From: Martyn White <Martyn.White@arun.gov.uk>
Sent: 22 April 2022 17:32
To: Planning.Responses <Planning.Responses@arun.gov.uk>
Subject: AB/24/22/L

AB/24/22/L

67 Flat High Street Arundel BN18 9AJ

Listed building consent to convert the first floor Restaurant into 3 No bedrooms and remove one bedroom on the second floor.

PROPOSED SECOND FLOOR PLAN

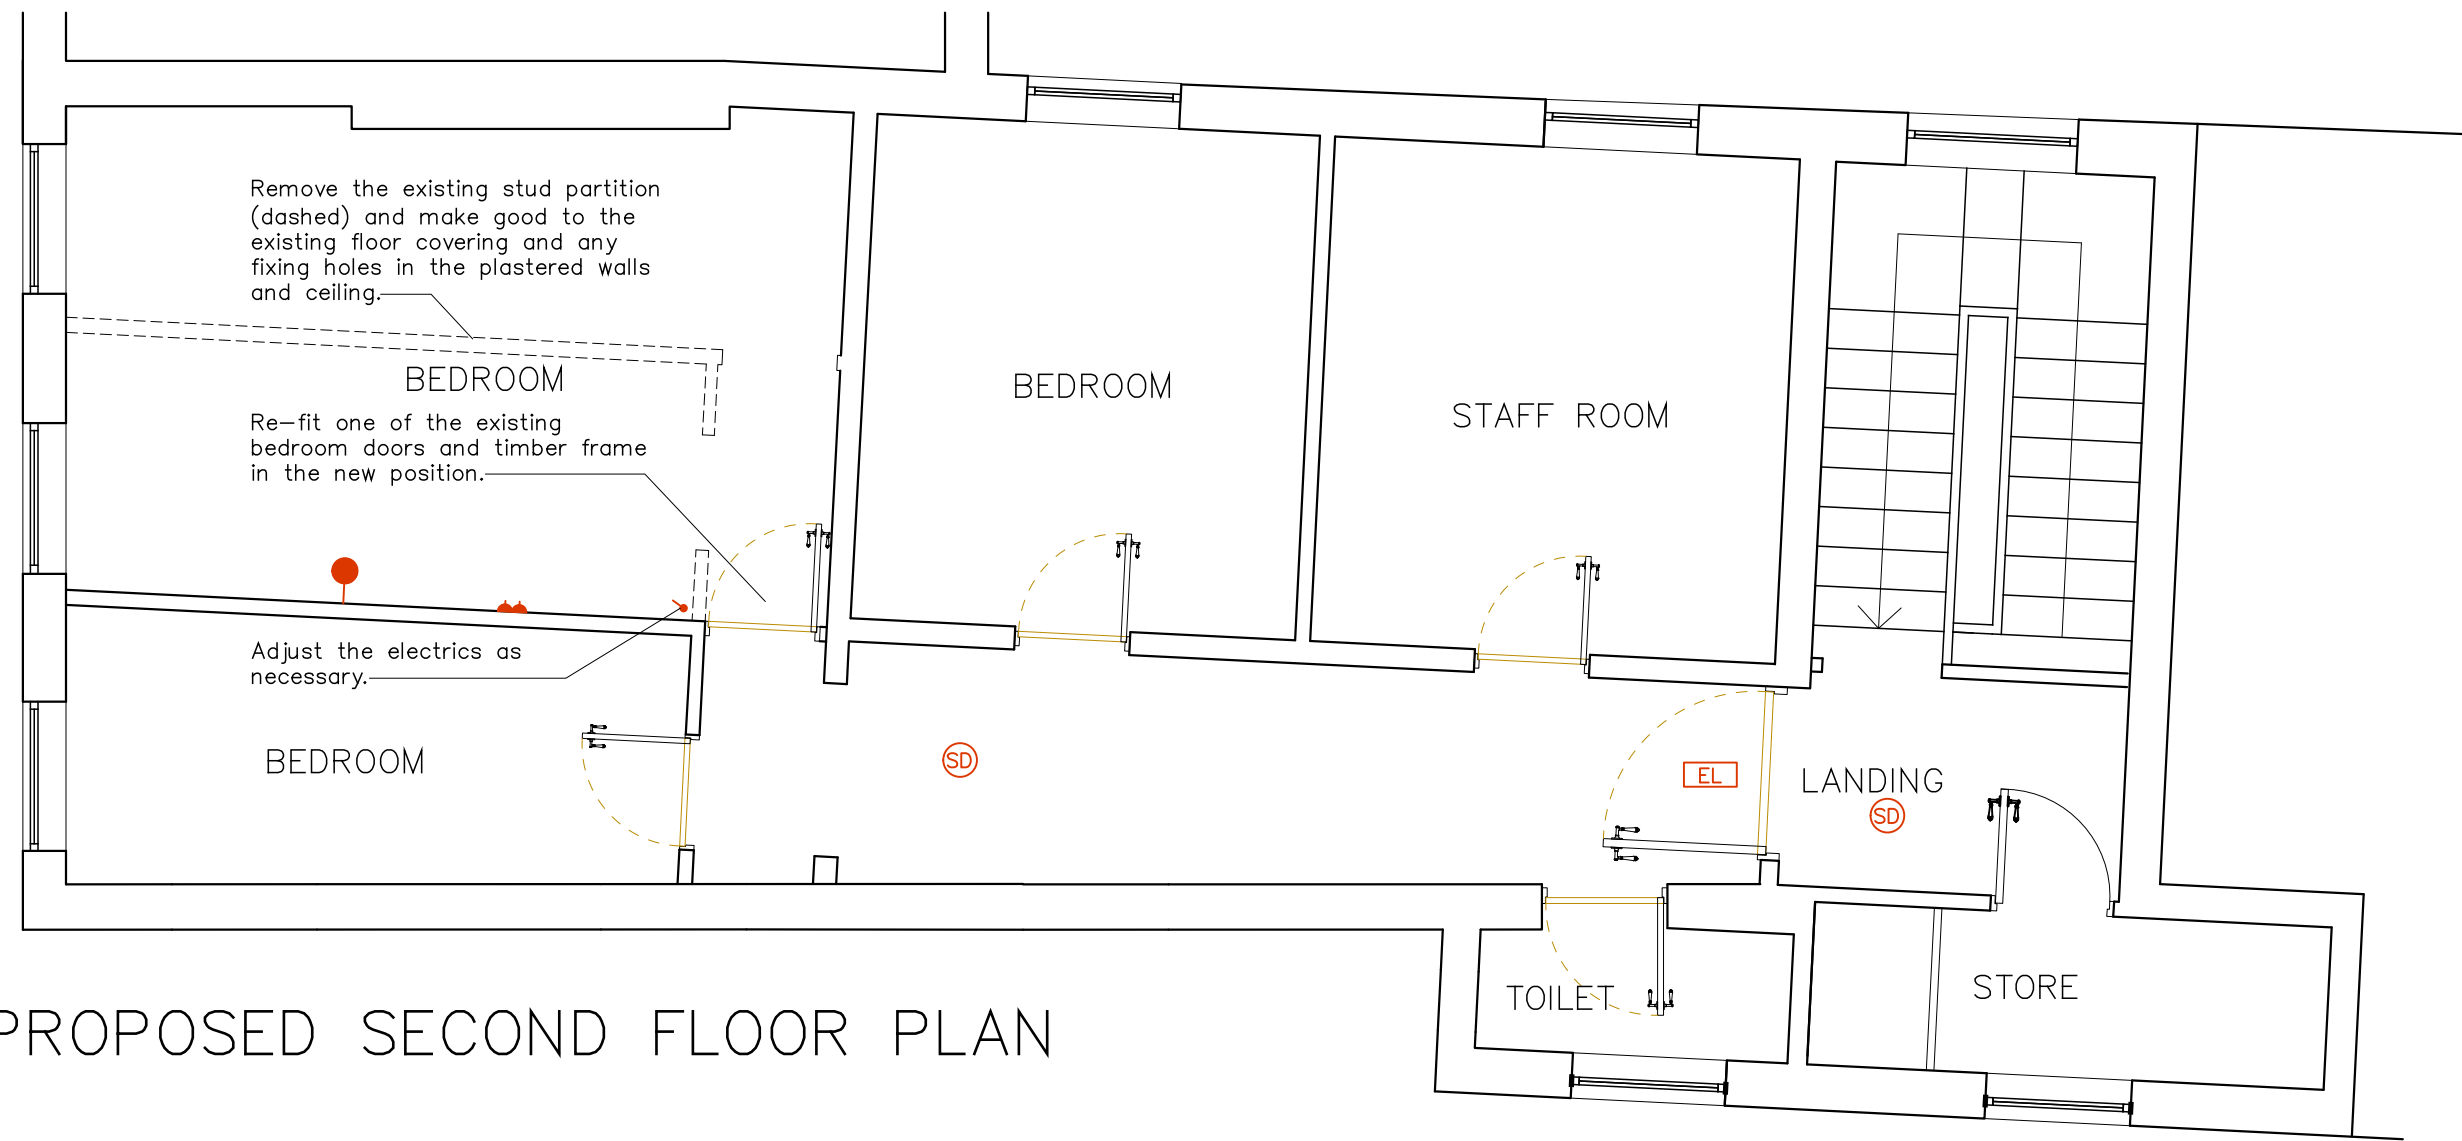
I note in the application statement that the new partitions will be made up with light gauge metal studs and a skin of 12.5mm thick plasterboard each side. Further, that where the partitions abut the ornate cornices,

strips of fire resistant foam will be inserted to avoid damaging these features. Such a proposal will ensure that the alterations are fully reversible and the spaces can be opened up at some point in the future. This is a positive feature and capable of making the proposal acceptable. The proposed new doors should reflect those found elsewhere in the listed building and further details should be provided regarding them. This can be achieved by way of condition.
